MARYSVILLE
COMMUNITY
DEVELOPMENT

Re: Evans Park PRD – First Final Plat Review (PA22-003)

TO: Amy Hess, Senior Planner
FROM: Brooke Ensor, NPDES Coordinator
DATE: 1/3/2023
SUBJECT: PA22-003 Evans Park Plat

SUBJECT: PA22-003 Evans Park
Final plat review of 14 lot plat
APN: 31052000301500

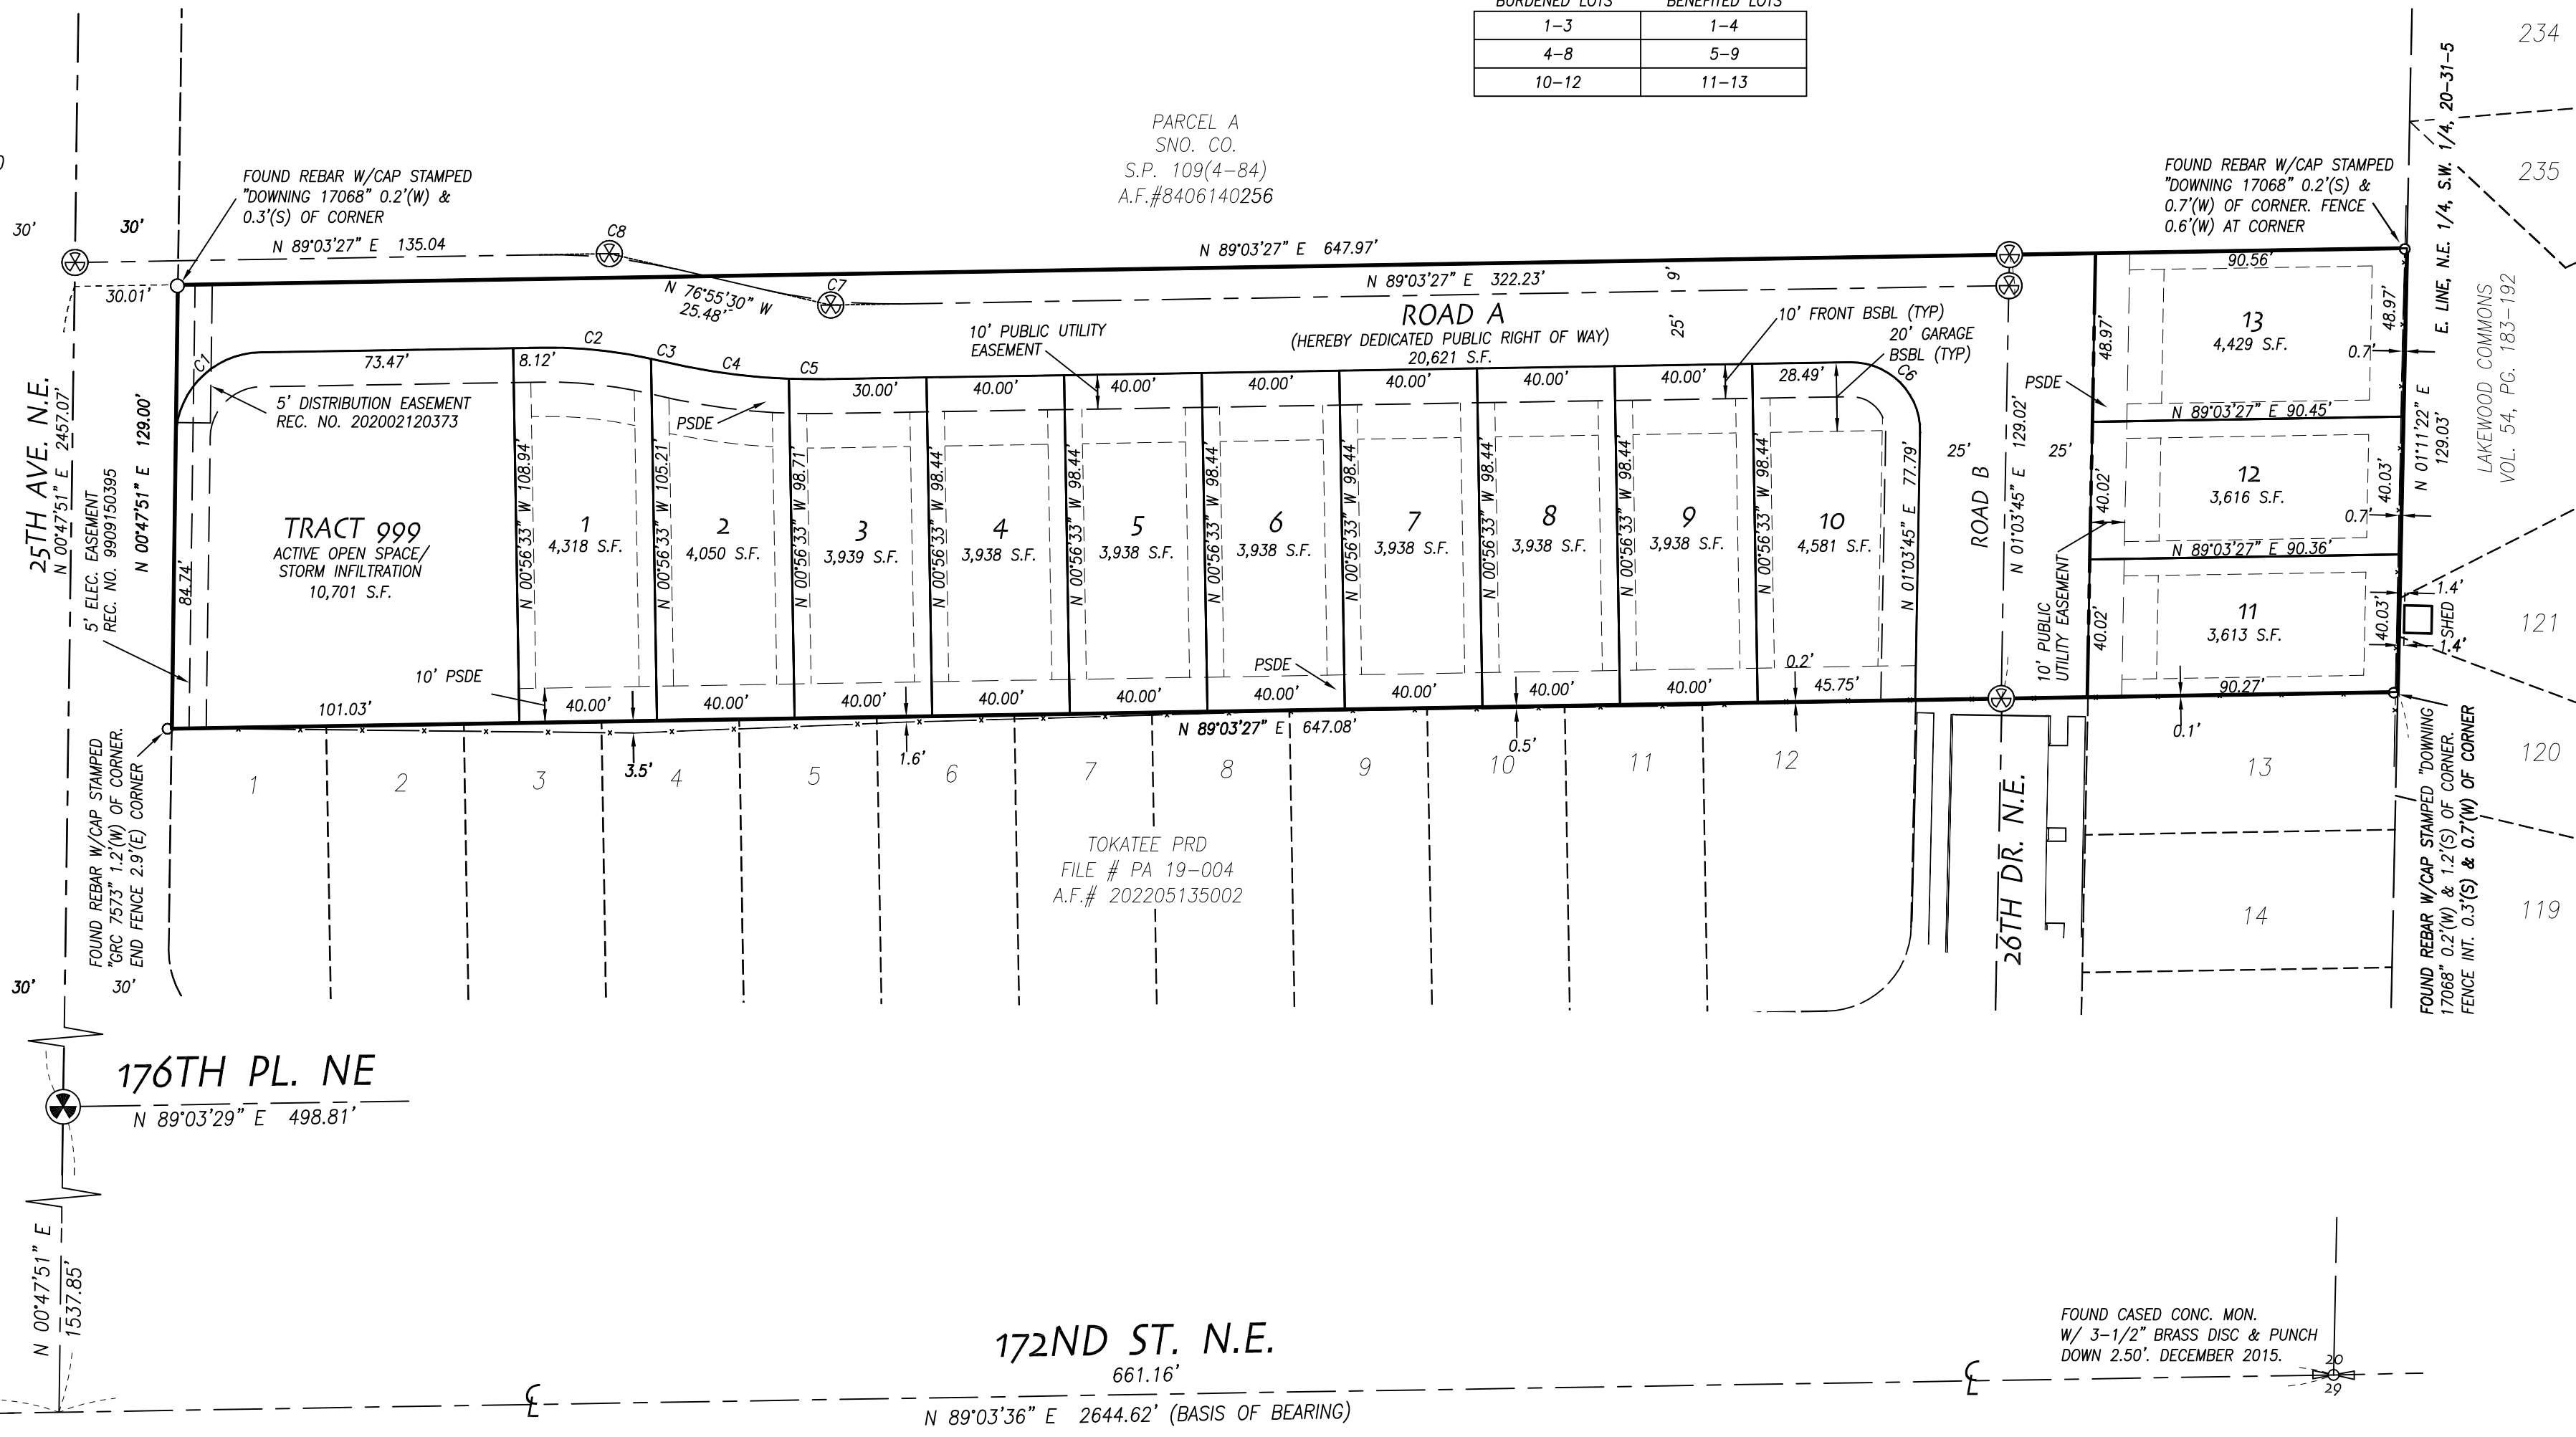
1. Contact Jon Wessel, Construction Inspector, at 360.363.8218 or jwessel@marysvillewa.gov regarding any construction items which must be completed.
2. Please depict PUD easement identified by AFN 202207190309 on the final plat map.
